DRB Application No.: 08DRB-70331

Project Name: EAST CENTRAL BUSINESS ADDITION

**June 25, 2008  
DRB Comments**

**RE: Lots 1-3 & 32-34, East Central Business Addition**

PLAT OF
 LOT 1-A
 BLOCK 3
 EAST CENTRAL
 BUSINESS ADDITION

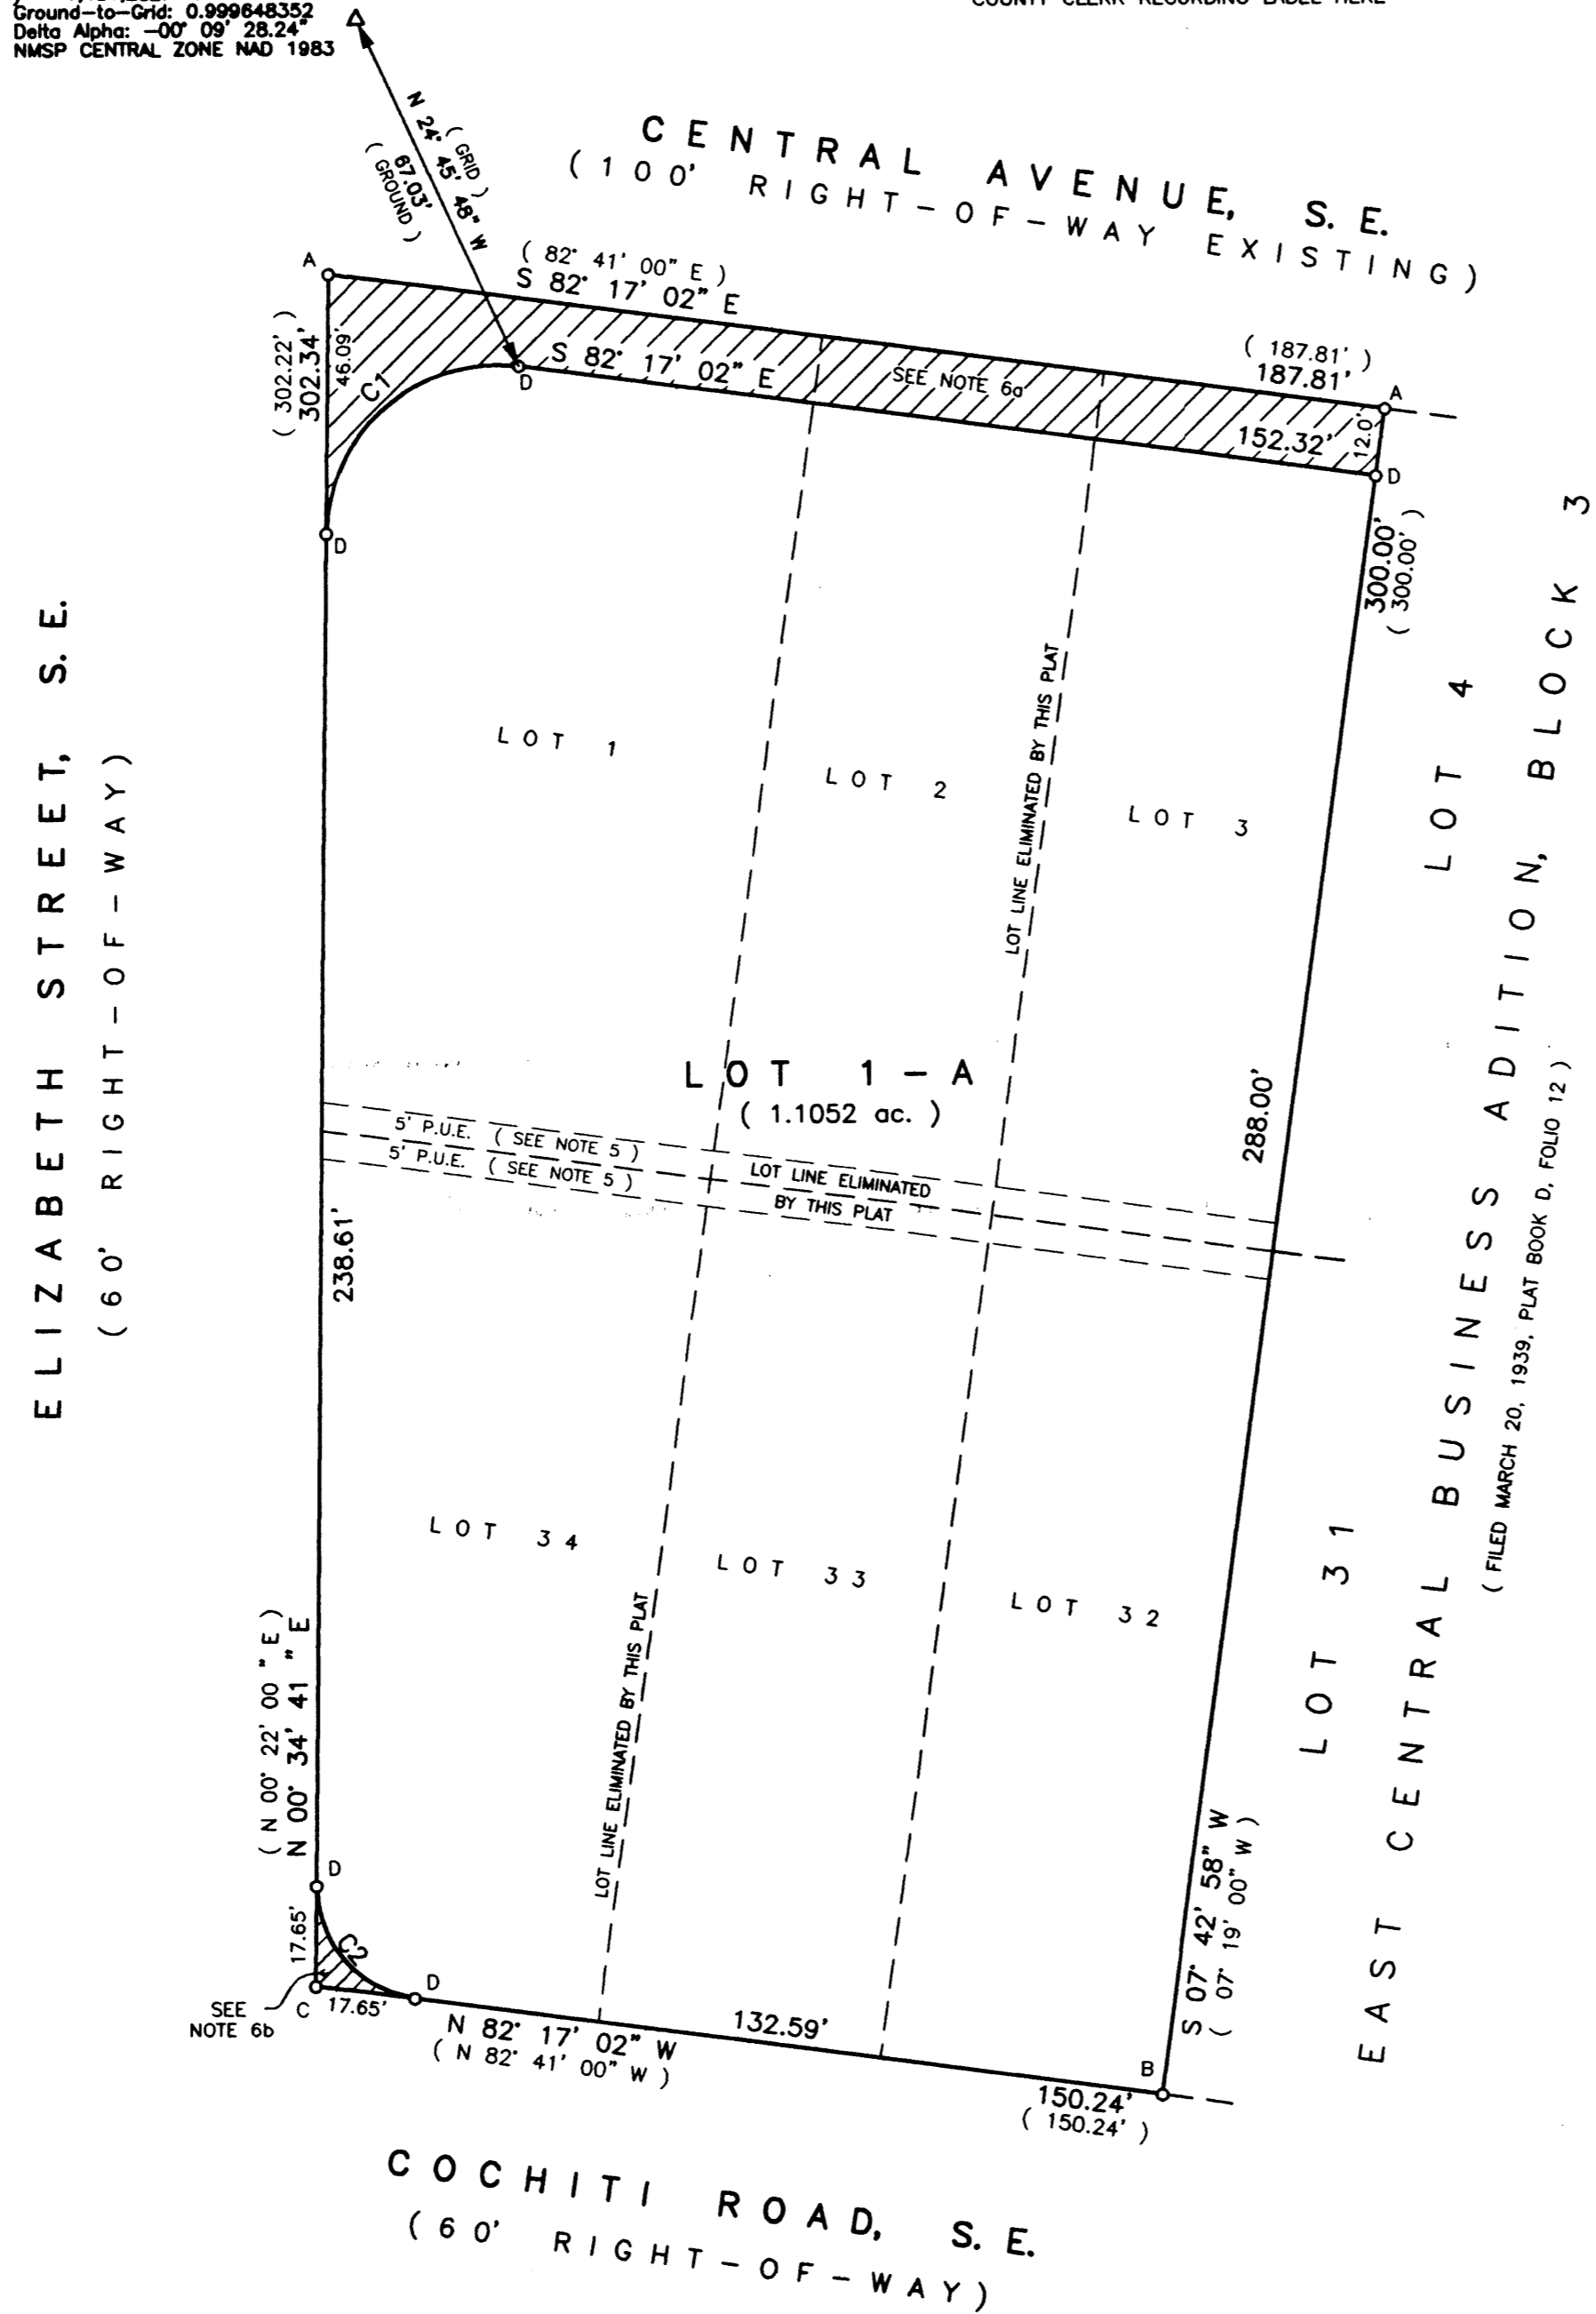
Please remove zoning designation from plat. Please use language in the solar collector note to be specific to this type of request, i.e. use the words "THIS PLAT" and not "REQUESTED FINAL ACTION" in the beginning of the note and delete the words "OR SITE DEVELOPMENT PLAN FOR SUBDIVISION" from the end of the note.
